# CITY OF PORTLAND BUILDING PERMIT

Located At 68 IRVING

Job ID: 2011-02-446-DUP

has permission to Fire Blocking, handrails, fire doors, new electrical, plumbing after fire provided that the person or persons, firm or corporation accepting this permit shall comply with all of the provisions of the Statues of Maine and of the Ordinances of the City of Portland regulating the construction, maintenance and use of the buildings and structures, and of the application on file in the department.

# 3RD FLOOR

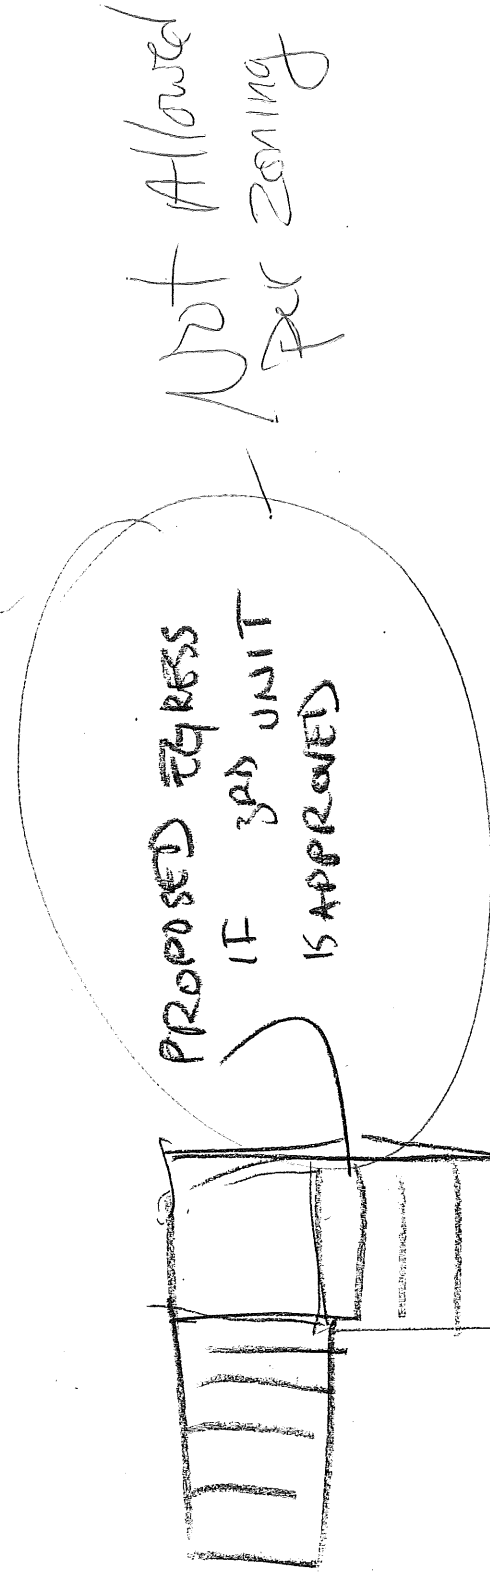
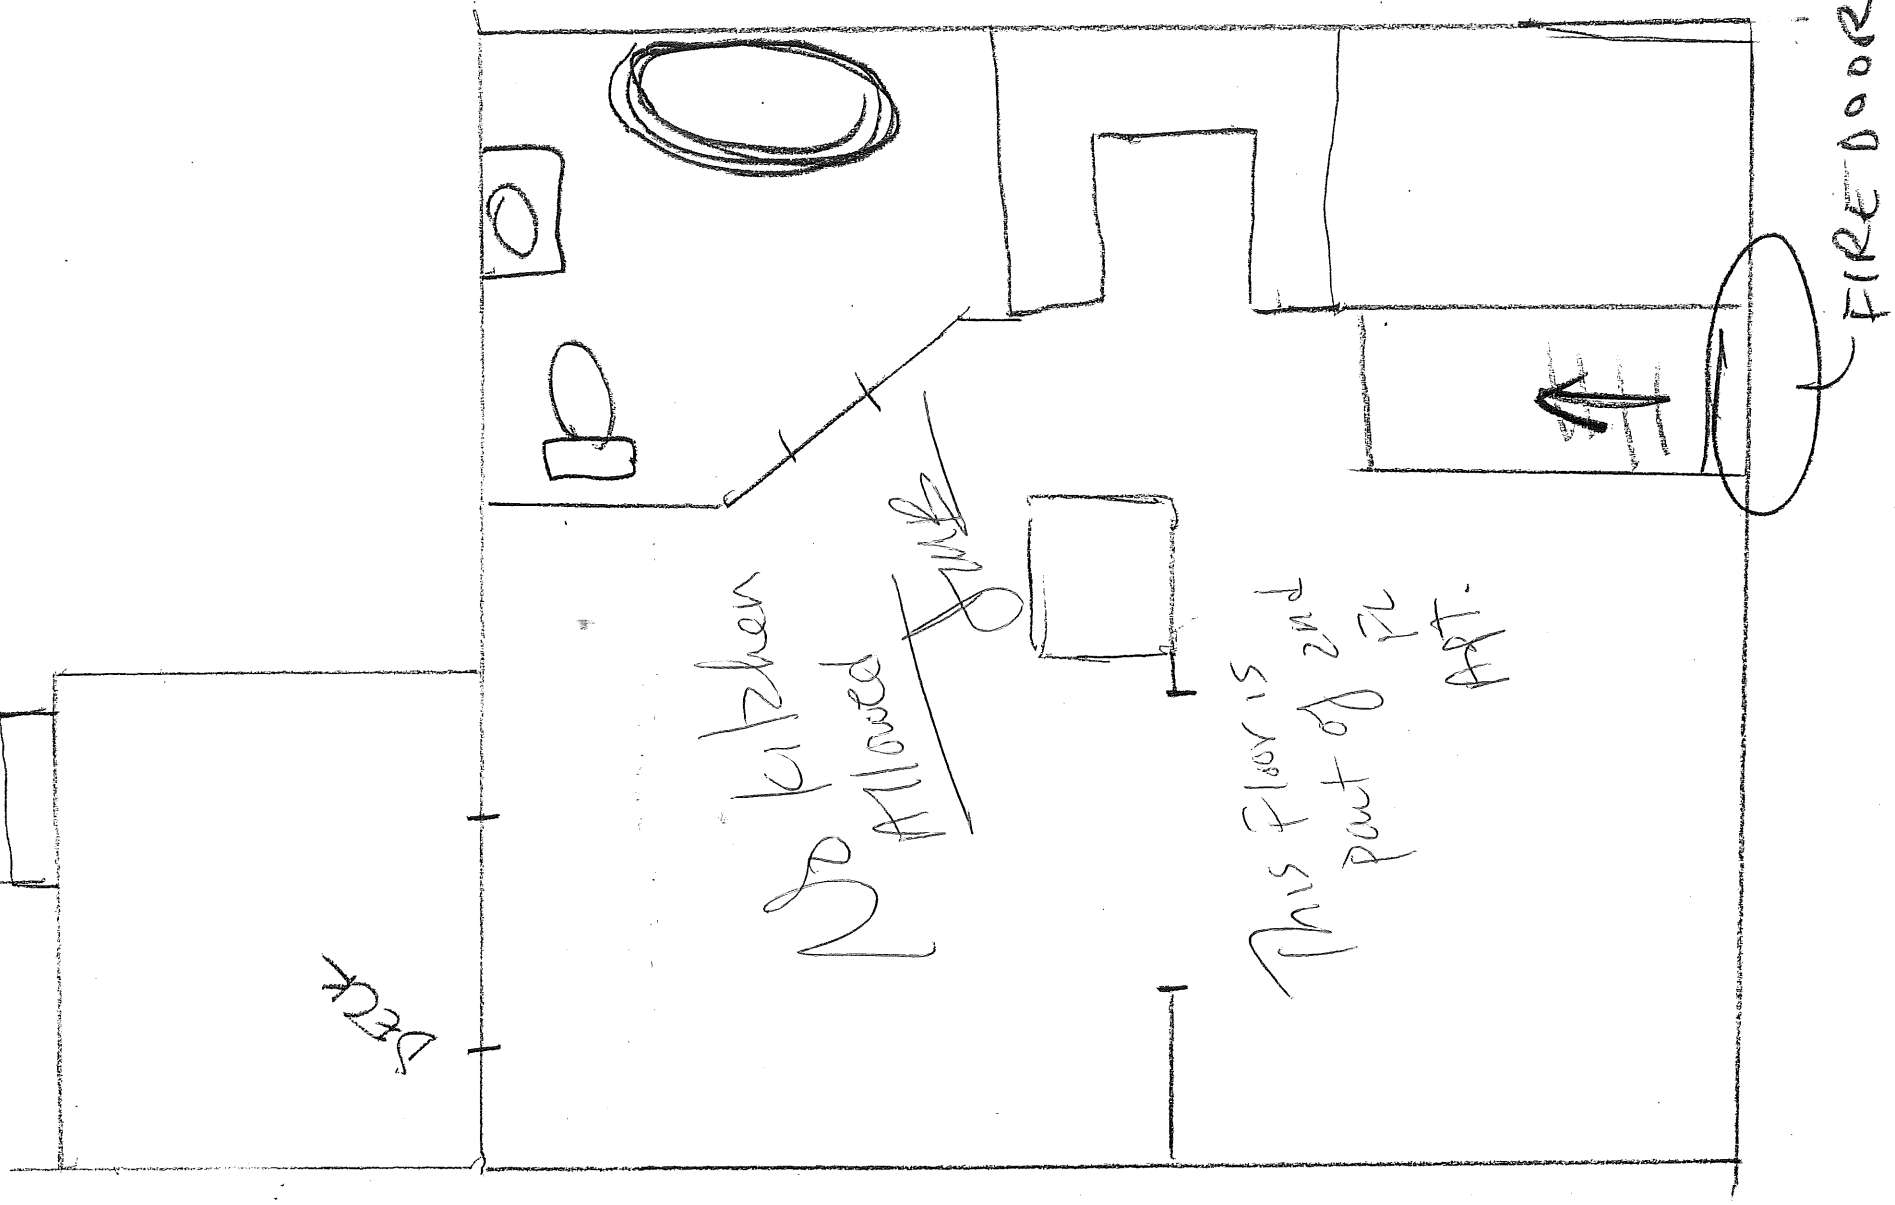
1. This permit is being approved on the basis of plans submitted. Any deviations shall require a separate approval before starting that work.
2. This property shall remain a two family dwelling. Any change of use shall require a separate permit application for review and approval. There is an illegal dwelling unit in the attic. The unit must be removed or the owner needs to apply to legalize it.

Not Allowed  
Per zoning
